**Document Review Assessing  
HDD through QEP  
Comments appertaining to  
ESSO's Site Specific Plans  
for QEP**

**Application by ESSO Petroleum Company Ltd  
for an Order Granting Development  
Consent for the Southampton to London  
Pipeline Project**

**Application Reference EN070005**

## Queen Elizabeth Park

Illustration A1.1. – HDD Cross Section

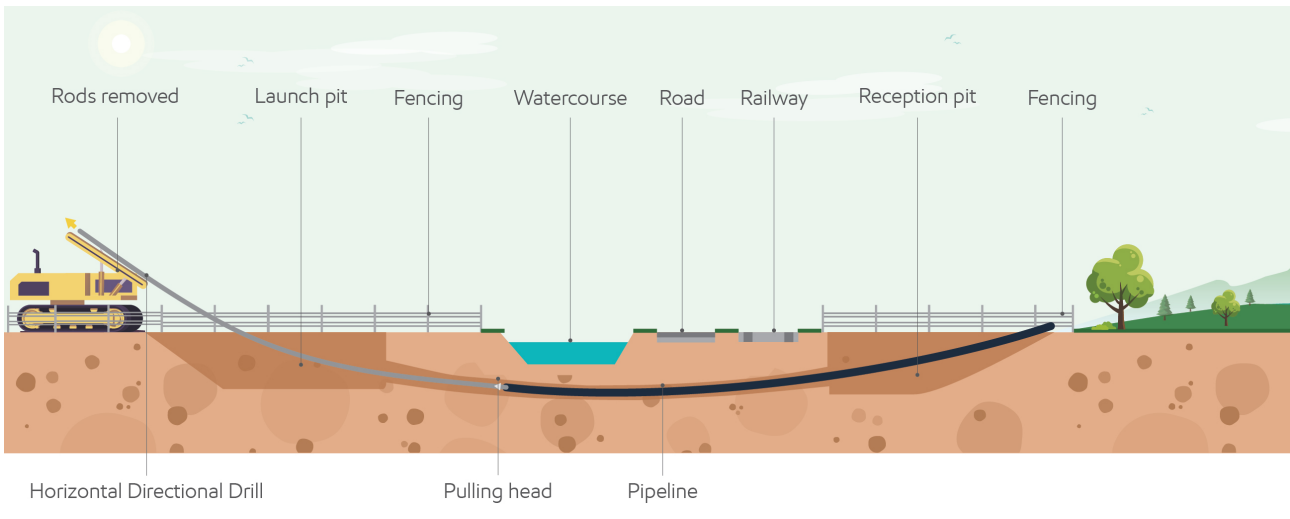
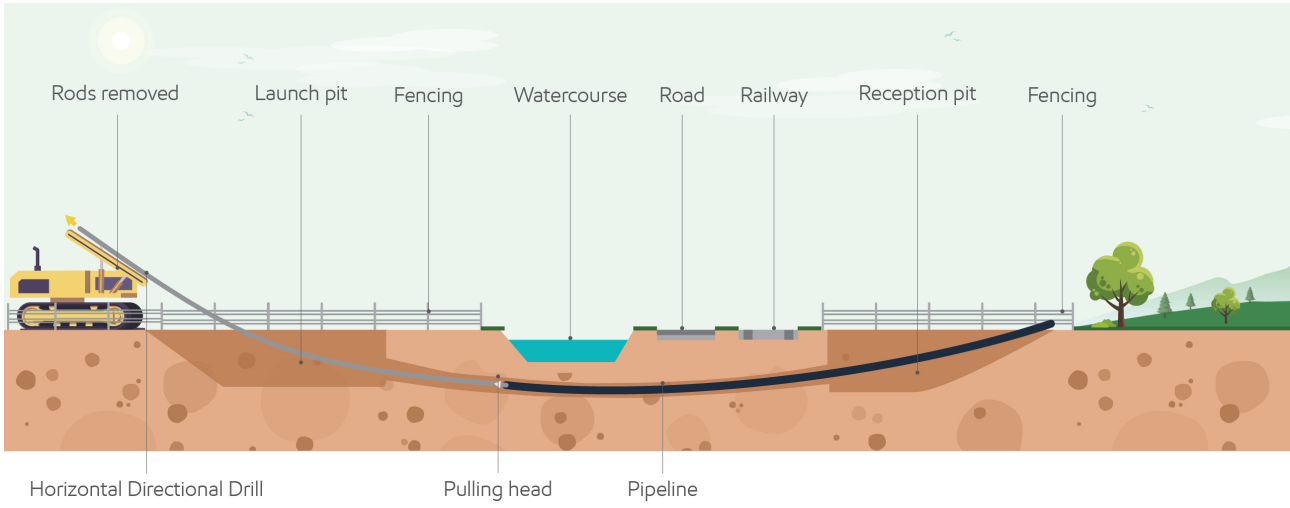
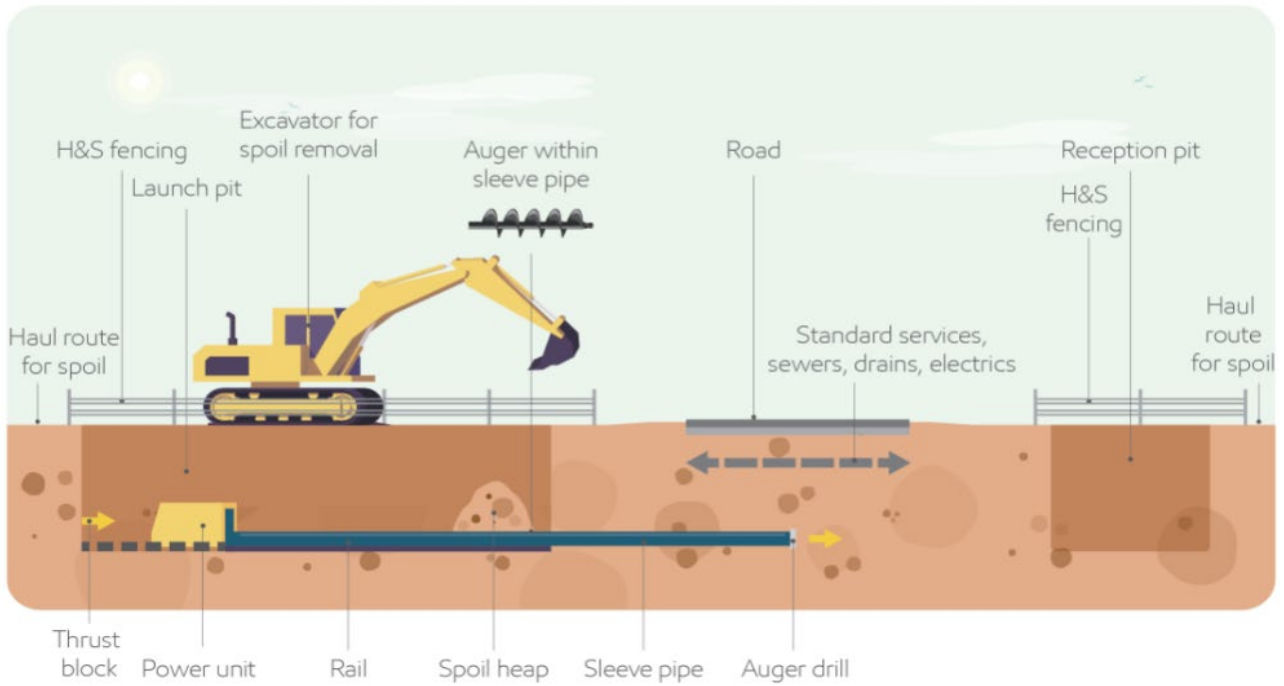
- 1.1.7 In relation to the two options presented, GEO Drilling Solutions is of the view that these options have not been optimised. Pipelines could be split; the radius and curvature of the pipeline string could be reduced with current figures appearing to be set high. Splitting the pipeline would also reduce the curvature of the stringing out area leading to less tree loss or disturbance within the SE corner of the park.

- 1.1.11 In regards to Option 1 GEO Drilling Solutions has concerns that *the radius of curvature appears to be larger than necessary*” and if shortened could be accommodated within the existing order limits. They feel *“There may be opportunity to reduce the minimum radius of curvature further. The HDD exit point site (‘receiving compound’) can potentially be moved further West, and the length of the HDD crossing increased”*

- 2.7.1 Within the GEO Drilling Solutions report a recommendation is made to reverse the HDD drill to limit the damage to the habitat due to the stringing out area. The string could be laid adjacent to the railway line and pulled through from Cove Brook Greenways. It is RBC's view that this should be able to be accomplished on the railway without loss of trees as a footpath is present parallel with the railway line and the trees are quite widely spaced along the railway corridor
- 2.7.2 In relation to the stepovers within the stringing out area RBC would expect an assessment to be undertaken regarding any ecological damage these will cause with habitat restoration provided once they are removed.
